Highways England

M4 Smart Motorway (Junctions 3 to 12)

Update on CCTV Provision February 2016

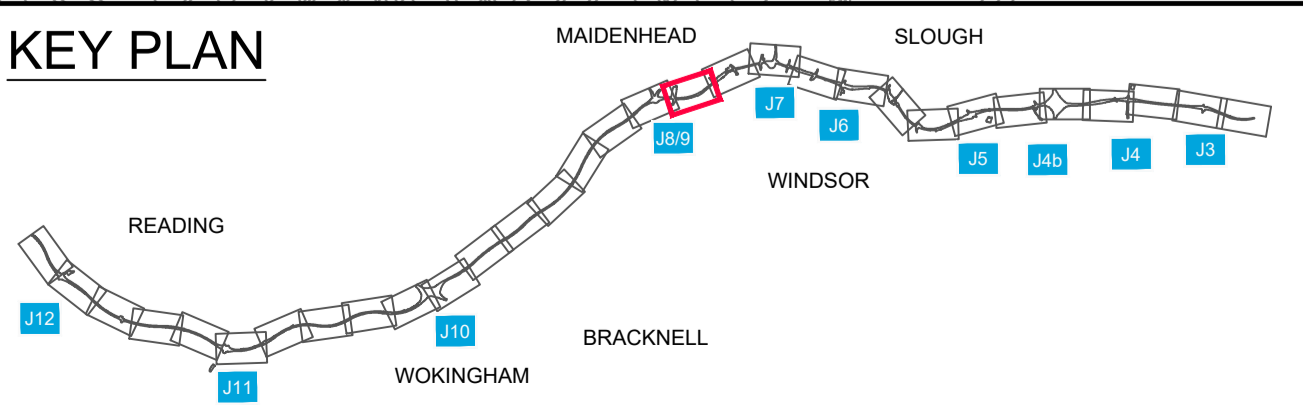
- 3.2 Camera 64 on the eastbound carriageway at Chainage (Ch) 33064 (work plan sheet 18) requires relocation to the westbound carriageway at Ch 32960 where it will be located next to the new gantry in this area;

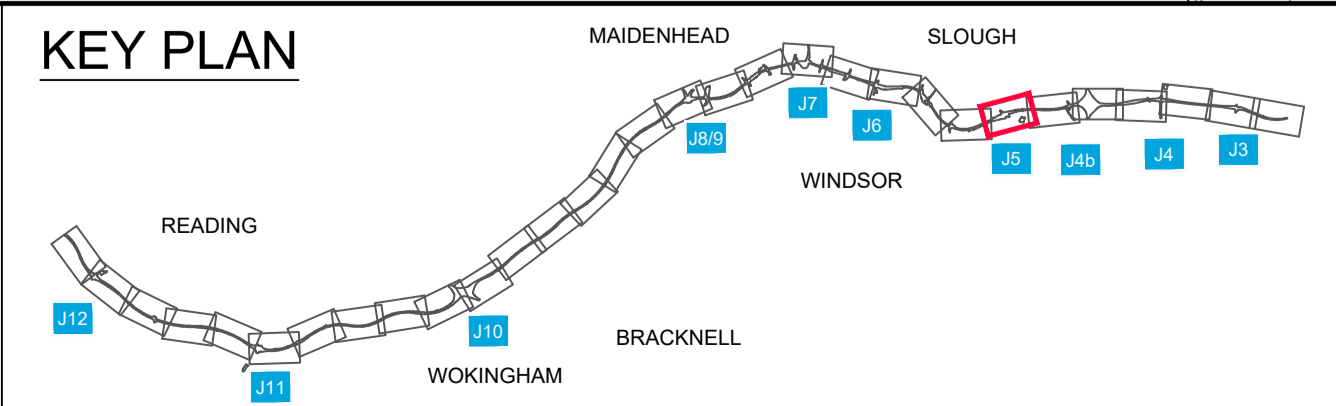
- 3.3 Camera 66A adjacent to the J8/9 eastbound exit slip road (work plan sheet 17) is no longer required;
 - 3.4 20 cameras in addition to those shown in the work plans will be required at various locations between junctions 8/9 and 3 as detailed below:

Camera Number	Chainage	Drawing Number
001	10570	Works Plan Sheet 30
004	11919	Works Plan Sheet 29
007	12610	Works Plan Sheet 29
018	15578	Works Plan Sheet 27
022	17353	Works Plan Sheet 26
023	17795	Works Plan Sheet 26
030	20317	Works Plan Sheet 25
034	21964	Works Plan Sheet 24
036	22500	Works Plan Sheet 24
038	23265	Works Plan Sheet 23
041	24295	Works Plan Sheet 23
043	24871	Works Plan Sheet 22
045	25831	Works Plan Sheet 22
048	27060	Works Plan Sheet 21
050	27916	Works Plan Sheet 21
052	28610	Works Plan Sheet 20
055	29810	Works Plan Sheet 20
059	31049	Works Plan Sheet 19
062	32150	Works Plan Sheet 18
139	52100	Works Plan Sheet 7
